Appeal Decision

Appeal Ref: APP/R5510/D/17/3185889
48 Pole Hill Road, Uxbridge UB10 0QB

- The appeal is made under section 78 of the Town and Country Planning Act 1990 against a refusal to grant planning permission.
 - The appeal is made by Mr Syed Hussain against the decision of the Council of the London Borough of Hillingdon.
 - The application Ref 33924/APP/2017/1512, dated 7 April 2017, was refused by notice dated 12 September 2017.
 - The development proposed is described as "to remove roof of existing rear extension build out to match line and match the roof line with existing".
-

Site Address

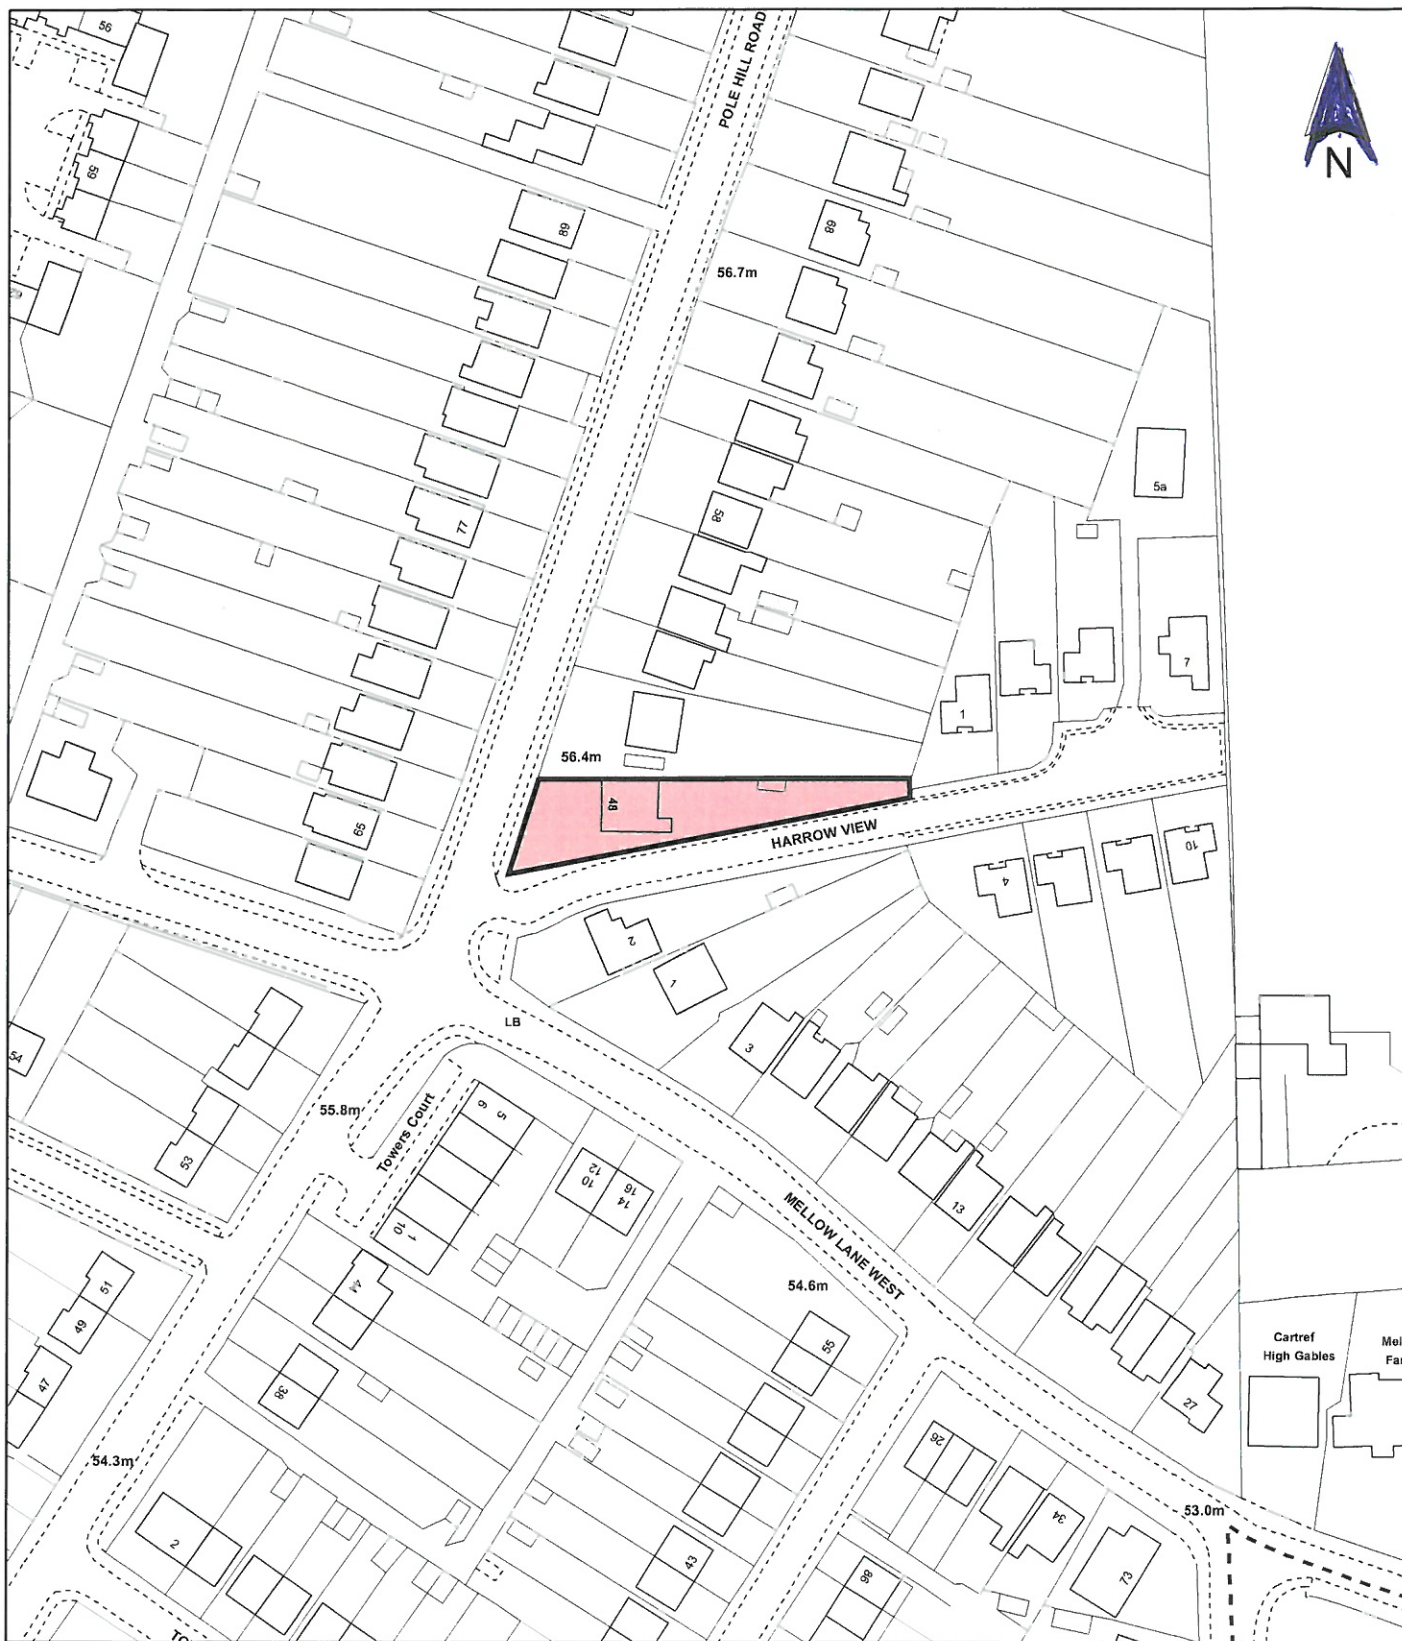
2. There is a discrepancy in how the existing building is shown in relation to the boundaries of the plot between that shown on the existing and proposed plans and elevations and that shown on the Block Plan and Location Plan. From my observations the more acutely tapering site shown on the latter two appear to more accurately represent the site's configuration. The effect is that the south east corner of the proposed extension would be situated closer to the site boundary than is shown on the proposed plan. I have dealt with the appeal on this basis.
3. The proposed drawings show a different configuration of dormer windows on existing and proposed plans and elevations. However the description of development does not refer to dormers and the Council determined the application on the basis that it related to a rear extension only. I have considered the appeal on the same basis.

CLIENT: MR HUSSAIN
JOB TITLE:
48 POLE HILL ROAD
HILLINGDON
MIDDX
SCALE: 1:250 @ A4

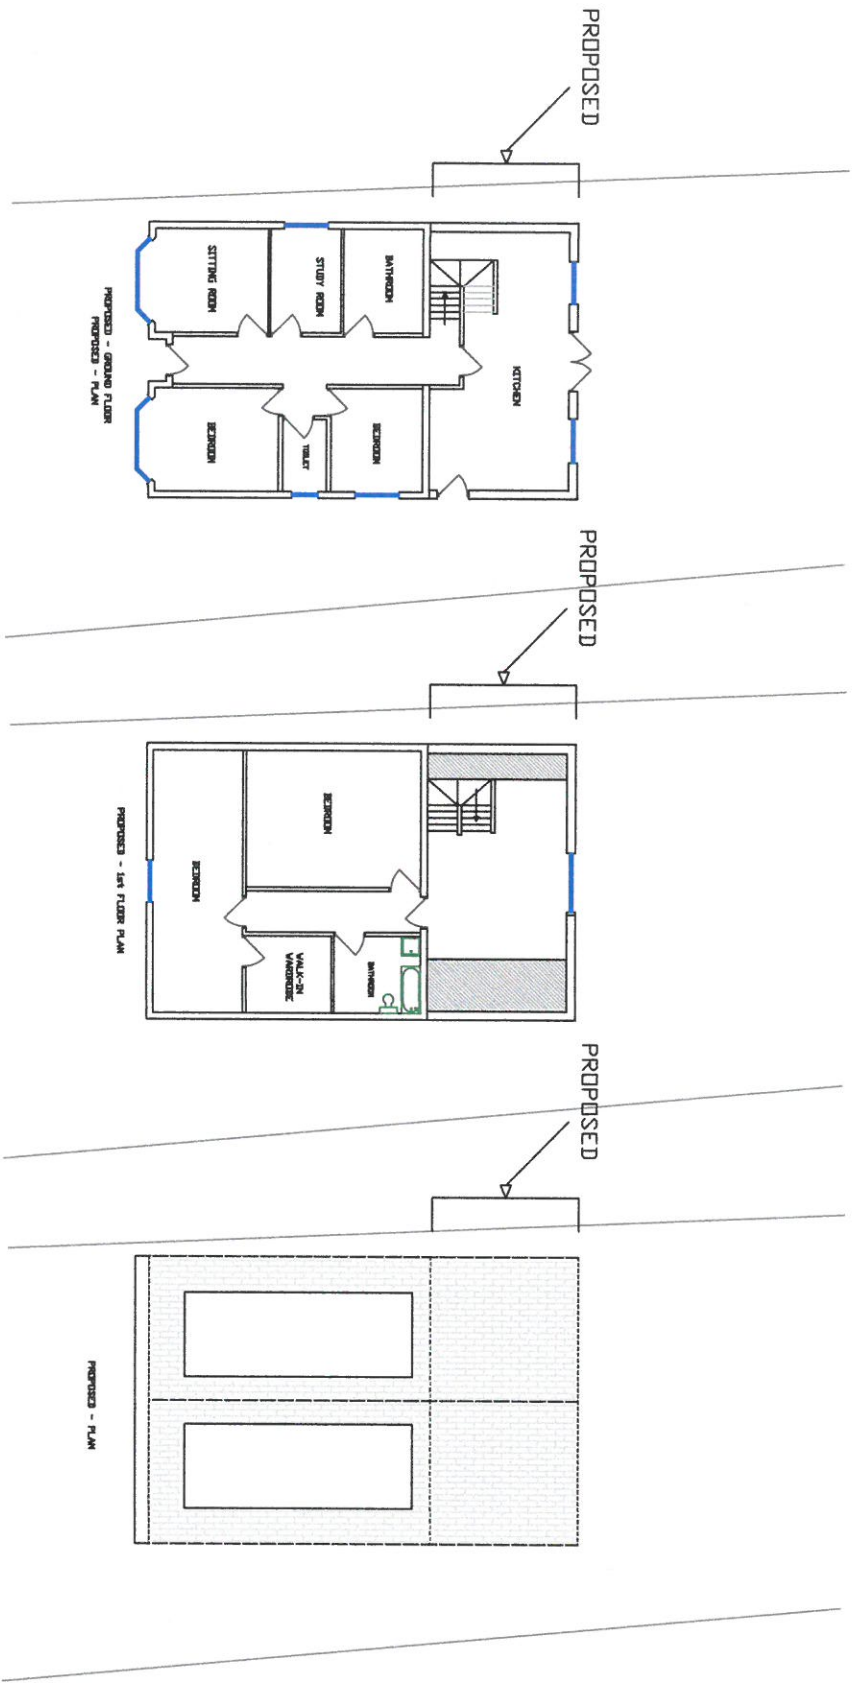
- a simple pitched roof configuration with gables to front and rear, large box type dormers on either side and single storey extensions to the rear.
6. The proposed extension would match the pitched roof form of the existing building and the drawings show that it would project rearwards slightly beyond the deepest of the existing single store extensions. The proposal would be simple in form, extending the main form of the host building rewards. However, the extension would be considerably closer to the site boundary than the existing rear gable or extensions due to the tapering nature of the site in relation to the side elevation of the property. As a result of its height, scale, bulk and massing at its nearest point to Harrow View it would appear cramped within the site and visually intrusive in the established streetscape along Harrow View when viewed in either direction.

7. The proposed extension would accord in some respects with advice in the Council's guidance¹ insofar as it would have a pitched roof which would not exceed the existing height and the roof and eaves lines would be parallel to those of the existing building. However the form of the roof, in extending the existing, would not be subordinate nor have a lower ridge height as advised in the guidance. Much of the remaining guidance for rear two storey extensions focuses on avoiding adverse effects on neighbouring properties, an aspect to which the Council raises no objection.

9. Whilst the proposal would have a simpler roof form than the three levels of roofs on the existing extensions it would replace or incorporate, any visual benefits this may bring would be outweighed by the detrimental effects of the extension on the wider character and appearance of the area.
